CITY OF ALBUQUERQUE

**Planning Department
Transportation Development Services Section**

Re: Certification Submittal for Final Building Certificate of Occupancy for
Warehouse on Aspen, [J-14 / D145]
300 Aspen Avenue NW
Engineer's Stamp Dated 09/23/05

SHEET TITLE: DRAINAGE AND GRADING PLAN

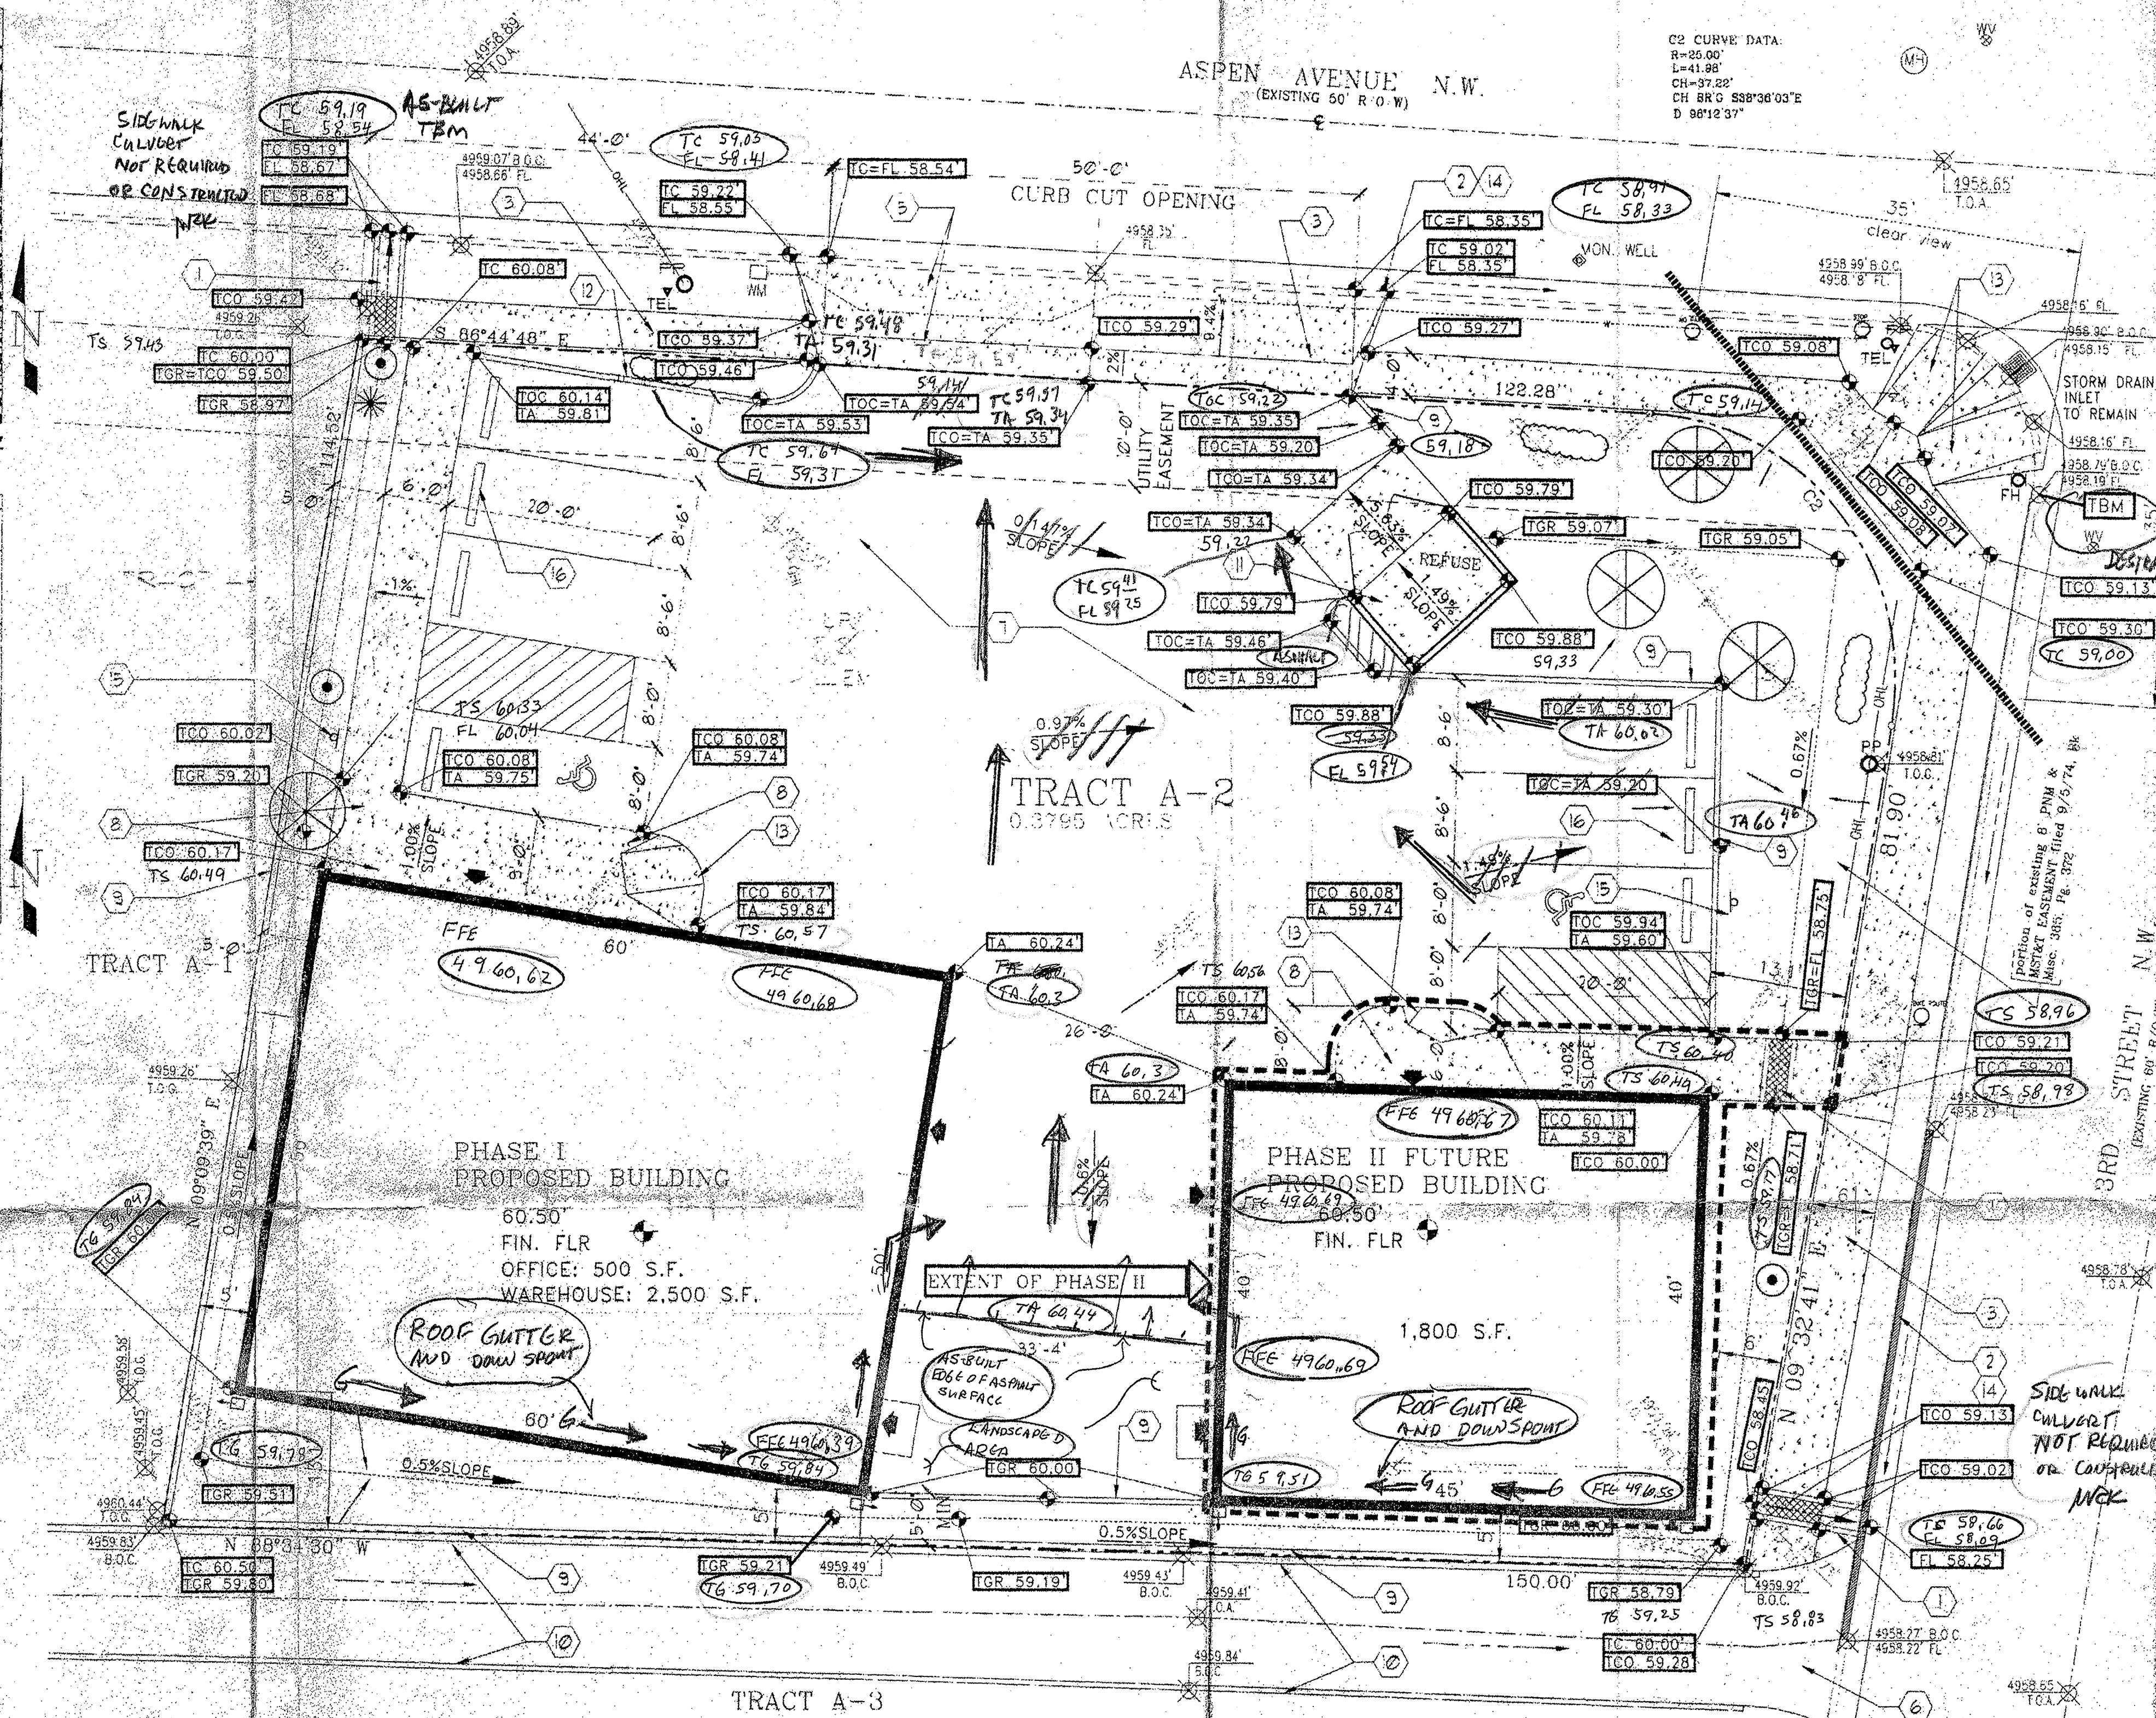
The TCL / Letter of Certification submitted on September 26, 2005 is not sufficient for acceptance by this office for final Certificate of Occupancy (C.O.). The following reasons for rejection: Safety hazard at proposed sidewalk culverts (On Aspen you have a deep hole which needs to be barricaded, and on 3rd Street adjacent to driveway the sidewalk is cracked and has resettled causing a tripping hazard at this location); the true sidewalk widths needs to be reflected on plans; both sidewalk culverts are not in place and will need to be reflected on plans that are being certified for final C.O.

SHEET
AS-1

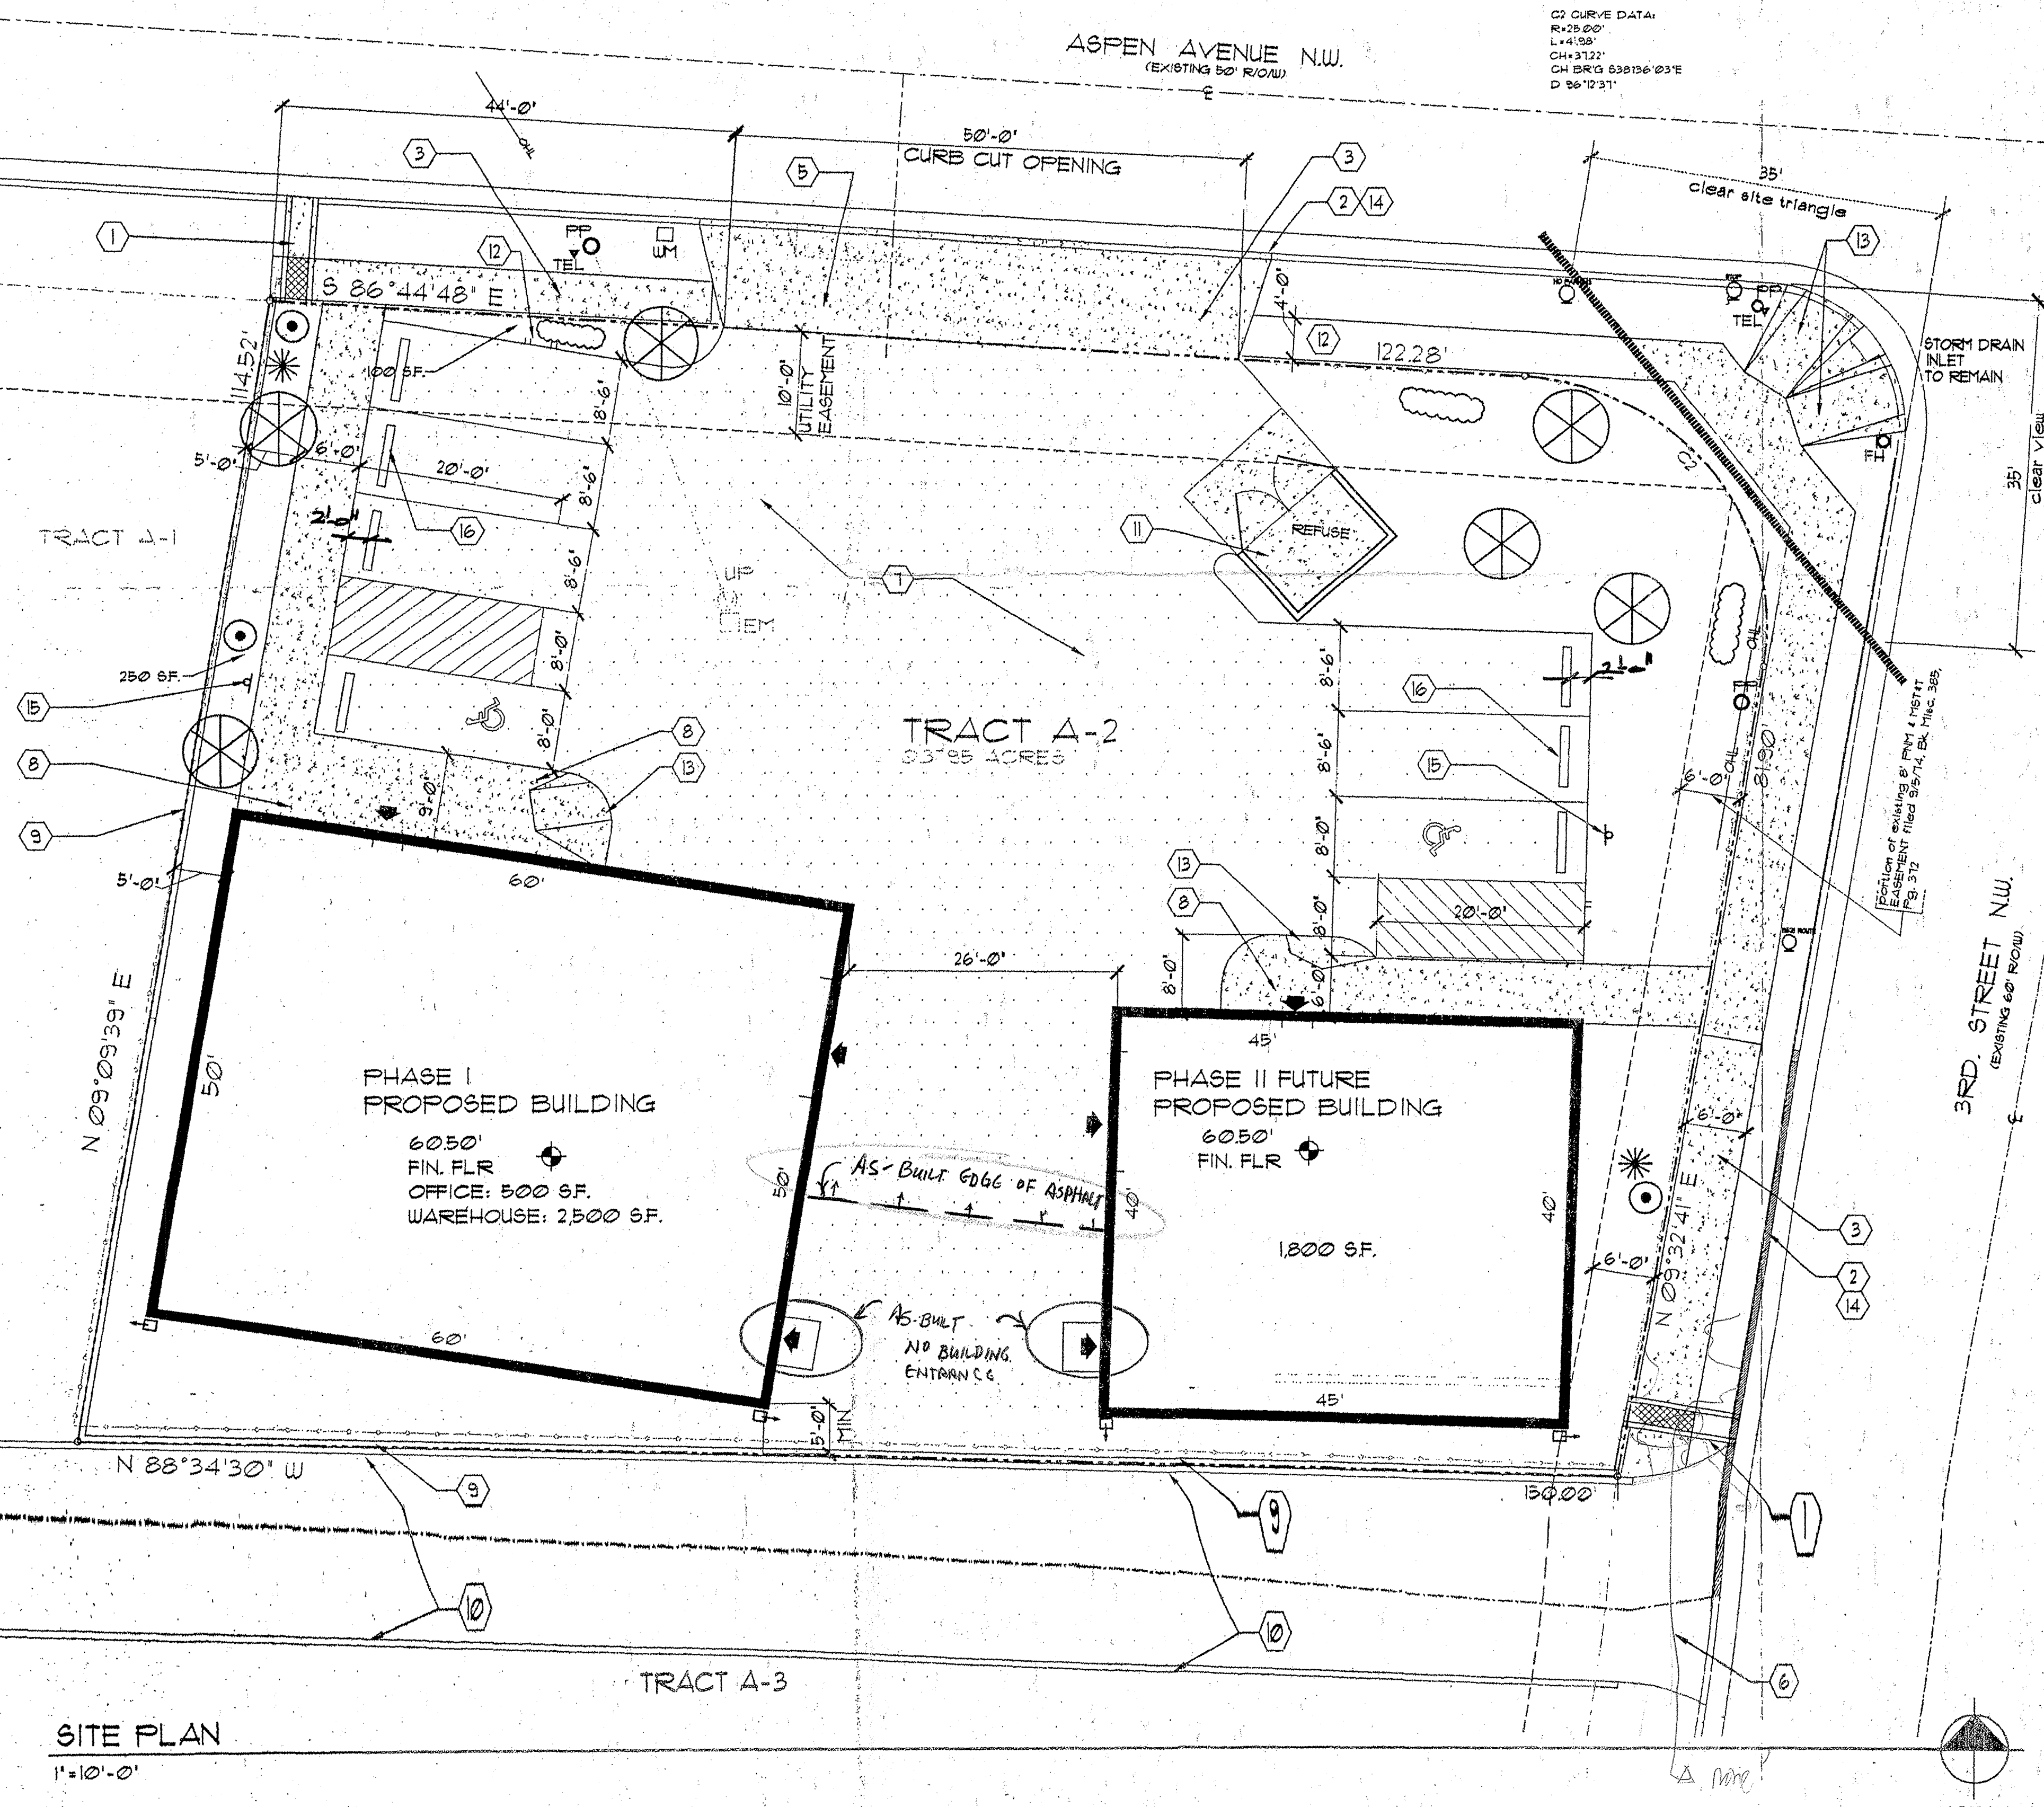
The TCL (or DRB Site Plan) submitted for Final C.O. needs to be the exact copy of the approved TCL in the plan set approved for building permit. This will be the latest edition, which may have redlined comments, initialed and dated by the designer-of-record.
